11th January 2019

Town & Country Planning Act 1990 (as amended)
Town & country Planning (Development Management Procedure) (England) Order 2015
Application for Planning Permission for Works or Extension to a Dwelling

Development Steplift to the front door.
Location 29 Beechfield Park Hook Lane Aldingbourne

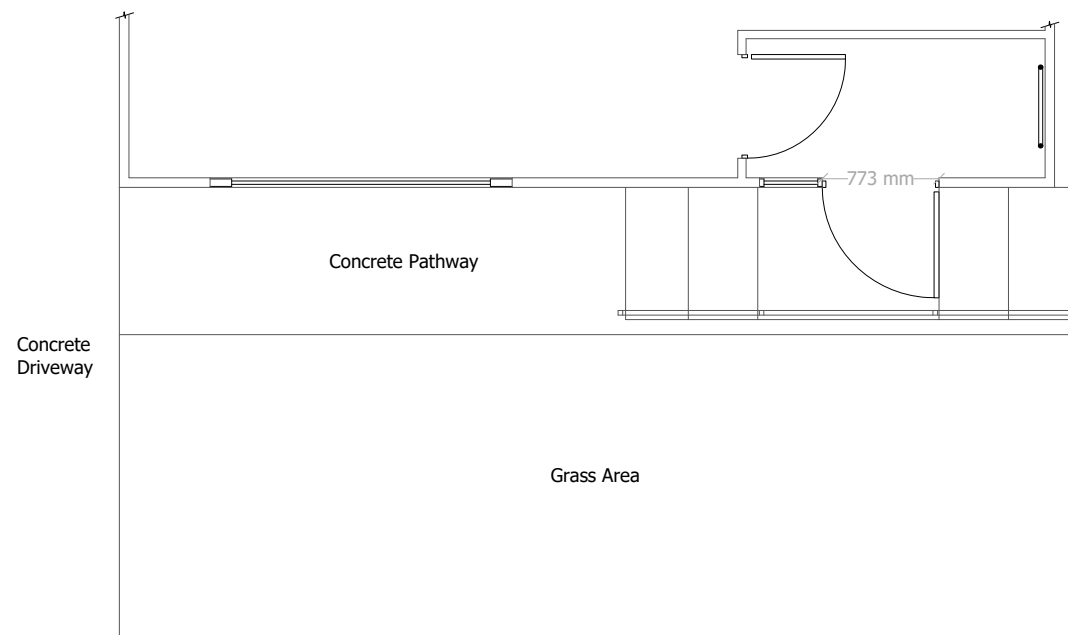
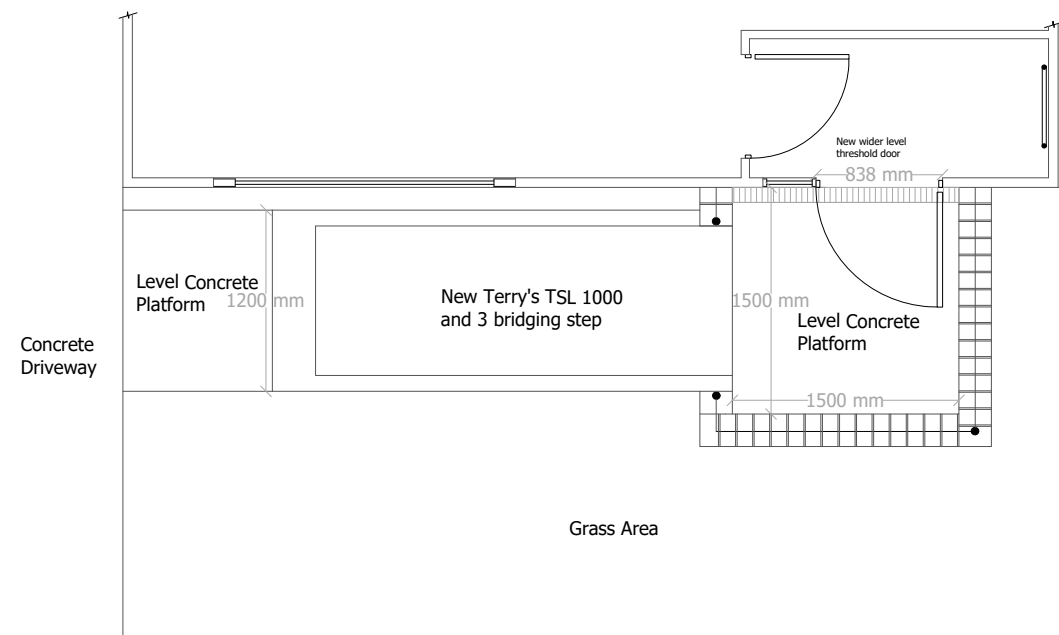
Block Plan: Please provide the other side dimension from the proposed steplift to the site boundary.
